Phone: (01772) 531343  
Email: peter.iles@lancashire.gov.uk  
Your ref: 3/2025/0057  
Our ref: 3\_2025\_0057-LCC  
Date: 28<sup>th</sup> February 2025

**Application 3/2025/0057: Listed Building Consent for installation of underfloor heating at ground floor.  
Waddington Hall, Clitheroe Road, Waddington BB7 3HP**

Drawing Title
Existing Ground Floor Plan

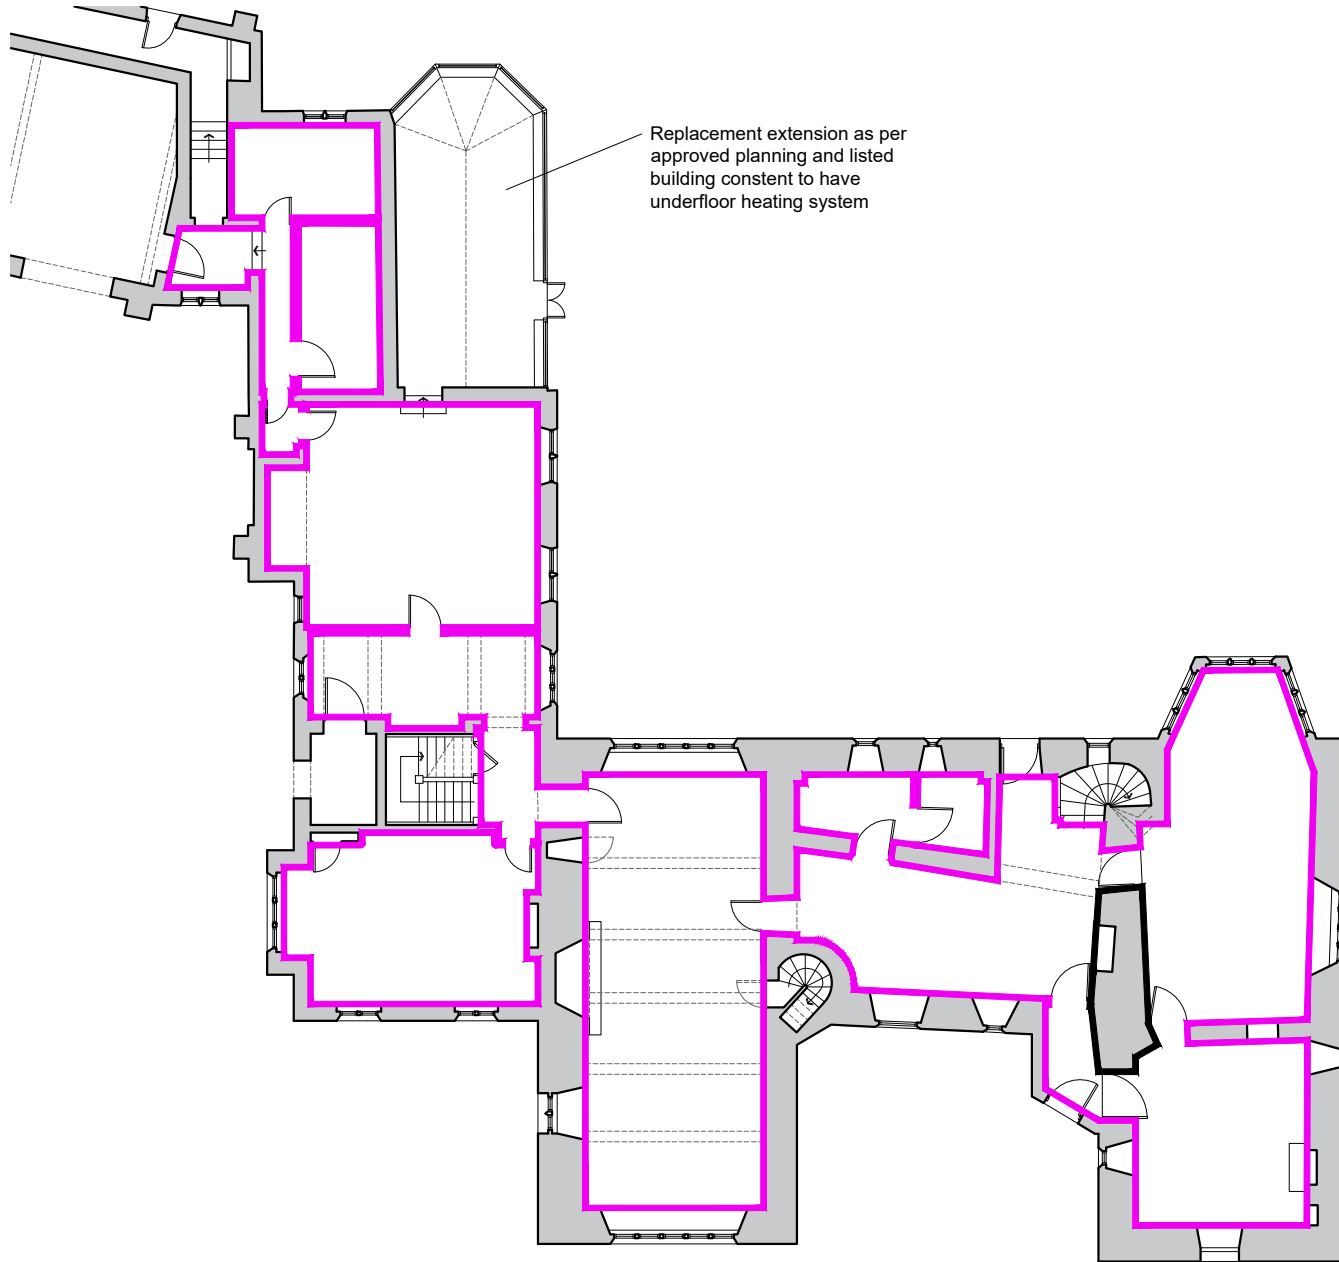
There may be practical difficulties in the implementation of the drawn proposals in some instances, particularly where it is proposed to remove the upper portion of a concrete sub-floor and retain the lower portion. In my (limited) experience normal concrete breaking tools are likely to fracture the extant concrete slab vertically to its full depth rather than at the desired horizontal level, leading to a loss of integrity of the desired lower concrete layer or its complete removal. Where there is an extant blinding or bedding layer, such as appears to be present in The Monks Room (drawing 6423-PRD1), the installation of a new concrete layer on top of the extant blinding or bedding should not cause any archaeological problems. Where there is no such bedding layer, as appears to be the case in The Morning Room (drawing 6423-PRD2), there is a risk of accidental penetration into earlier soils or deposits. In either case, dependent upon the proposed floor loadings (and Building Regulations, etc. – a minimum of 100mm thick seems to be commonly quoted on the Internet), there could be a requirement to excavate into that material to provide a sufficient formation depth for a new slab to accommodate anticipated floor loadings. Whilst the deposits which would be disturbed by this may also date to the same period as the installation of the concrete, this cannot be relied upon. A programme of archaeological monitoring and recording would therefore be required.

This potential requirement for a greater depth of concrete below the new underfloor heating than shown on the drawings (which varies between 50mm and 100mm), or the potential for that 'retained' level of concrete to be cracked and thus requiring to be replaced, is a detail that needs to be checked by an appropriately qualified engineer prior to any consent being given.

Once that detail has been checked and the drawings 'as proposed' approved, we would recommend that should consent be granted to the application, that a planning condition be applied requiring a scheme of archaeological monitoring and recording to be designed and implemented as part of the works, with an appropriate contingency plan in place in case of the discovery of unexpectedly significant or complex remains. The following wording is suggested:
